A303 Sparkford to Ilchester Dualling Scheme TR010036

9.33 Responses to the Examining Authority's Third Written Questions

Responses to the Examining Authority's Third Written Questions

Regulation Number:	
Planning Inspectorate Scheme Reference	TR010036
Application Document Reference	9.33
Author:	A303 Sparkford to Ilchester Dualling Scheme: Highways England Project Team

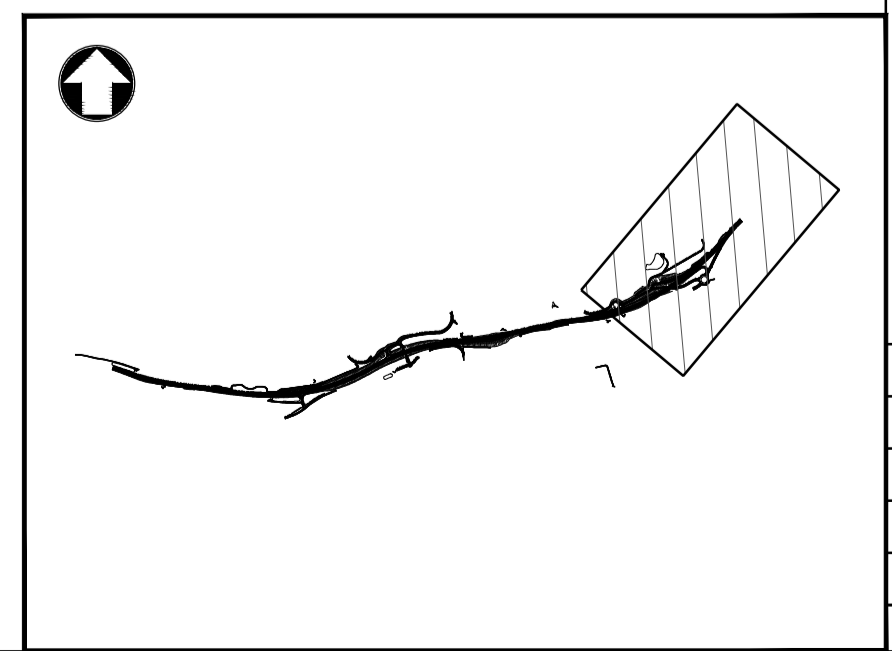
3.0.12	The Applicant SCC SSDC	<p>Scheme Lighting Within the draft Statement of Common Ground between the Applicant, SCC and SSDC [REP5-017], SCC comments on the responsibility of the proposed lighting system. The Applicant states that this is a matter of detailed design.</p> <p>It is unclear why this should be a matter of detailed design. What mechanism is in place to address this detail?</p>	<p>It has been the Applicant's approach throughout this process that responsibility for lighting should be determined once the design has been prepared and agreed in line with the limits of responsibility for all of the relevant parts of the detailed design. The Applicant has attempted to consult with Somerset County Council in relation to the proposed lighting design since the outset of preparing the DCO application, but to date have not received any feedback from the County Council's lighting team. The design, and subsequent agreement regarding maintenance responsibility, will therefore now be the subject of Requirements 12 and 15 of the draft Development Consent Order (REP5-005). The details to be approved under Requirement 12 include the limits of responsibility. Requirement 15 secures the requirement for a detailed lighting design to be approved in writing by the Secretary of State following consultation with the relevant planning authority and the local highways authority.</p>
